RE: EIS Thrumster Wastewater Scheme – Port Macquarie (SSI-56980459)

BCS and NPWS Assessment Summary for Thrumster Wastewater Scheme Environmental Impact Statement (SSD 56980459)

ATTACHMENT C Detailed comments for Thrumster Wastewater Scheme Environmental Impact Statement (SSD 56980459)

Figure 3.6 *Proposed WWTP location in existing wetland environment*

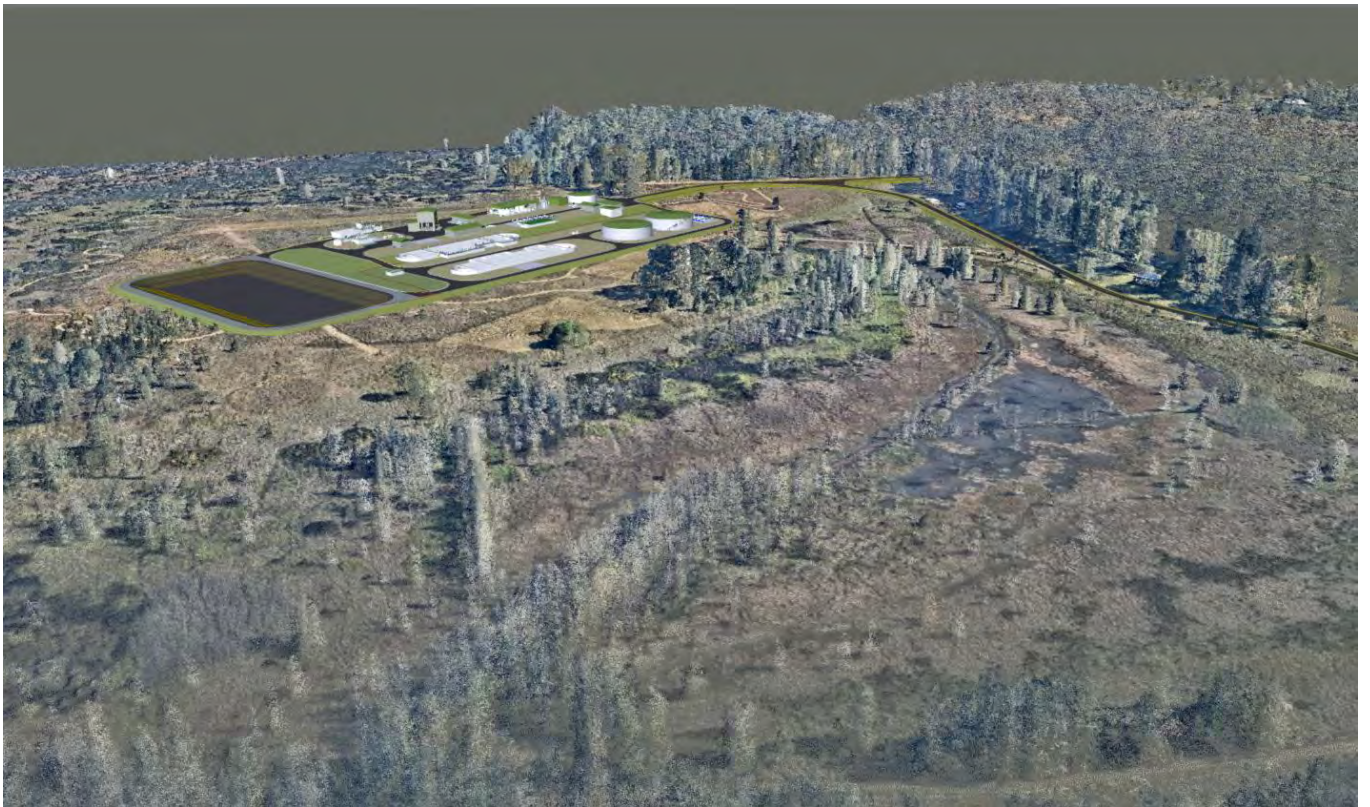
The BDAR does not provide details of the works proposed within most of the wetland area that would be impacted, however Figure 3.2b of the EIS shows the area is an indicative compounds/laydown area. Section 7 of the BDAR (Avoid and Minimise Impacts) does not meet the requirements set out in sections 7.1 and 7.2 of BAM as it does not include details of how the compounds/laydown area have been located or designed to avoid and minimise impacts.

Based on discussions between BCS officers and a project representative from Port Macquarie Hastings Council during our site inspection, BCS understand that direct impacts to the wetland can be largely avoided with the higher elevation sandplain area likely to have sufficient space for the compounds/laydown areas (*Figure 1*).

Given the high biodiversity values of the wetland area (including providing habitat for Giant Dragonfly) and ability to redesign project components in this area, BCS considers the proponent should avoid and minimise impacts further.

1. The proponent refines the project design to further avoid and minimise impacts to the high condition wetland areas.
2. The assessor amends the BDAR to document all measures the proponent has taken to avoid and minimise impacts in accordance with Sections 7.1 and 7.2 of BAM.
